From: Simon Davis
Sent: 20 February 2019 16:35
To: 'Charlie Brown' [REDACTED]
Cc: David Keene [REDACTED]
Subject: RE: Planning Consultation on: BE/137/18/PL

APPLICATION NO: BE/137/18/PL

Site Address: Rolls Royce Motor Cars Technology and Logistics Centre
Newlands Road Bersted

Description of Works: Temporary storage building & associated works

Proposed Site Layout Plan

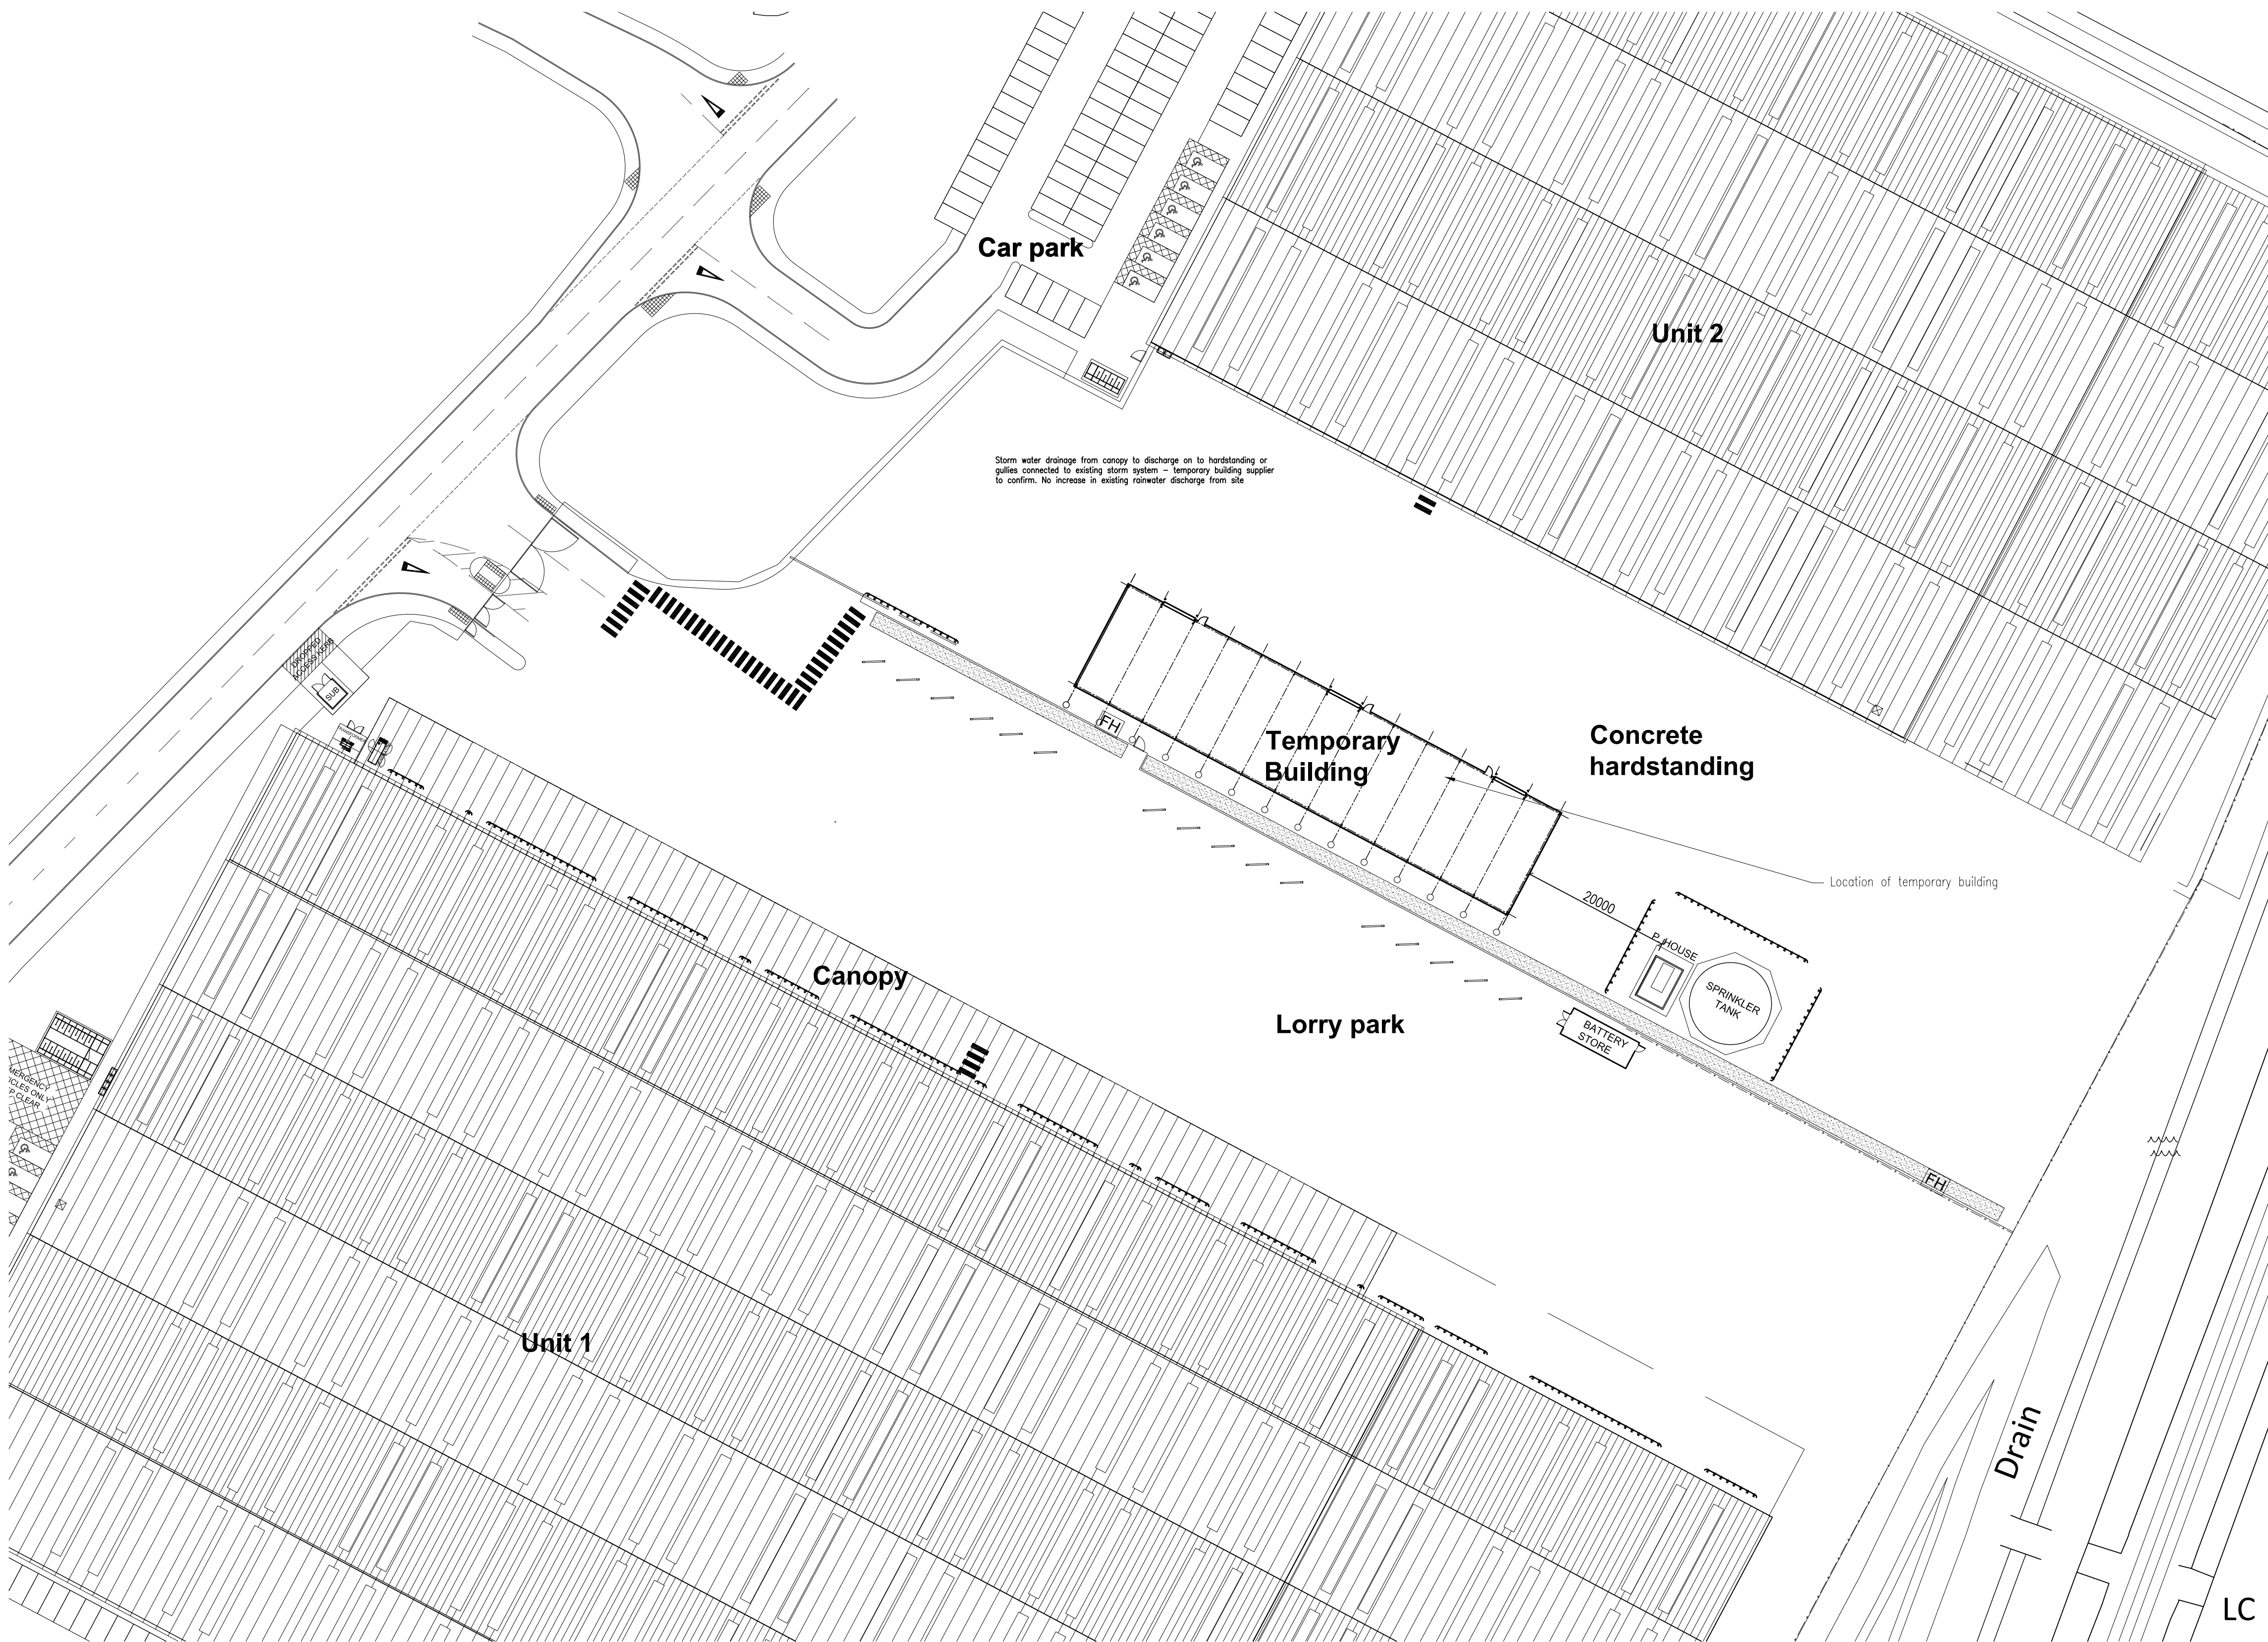
We require confirmation that the proposed temporary structure will not be located directly on top of the existing surface water drainage network. Please can the applicant provide as built survey of the surface water drainage network.
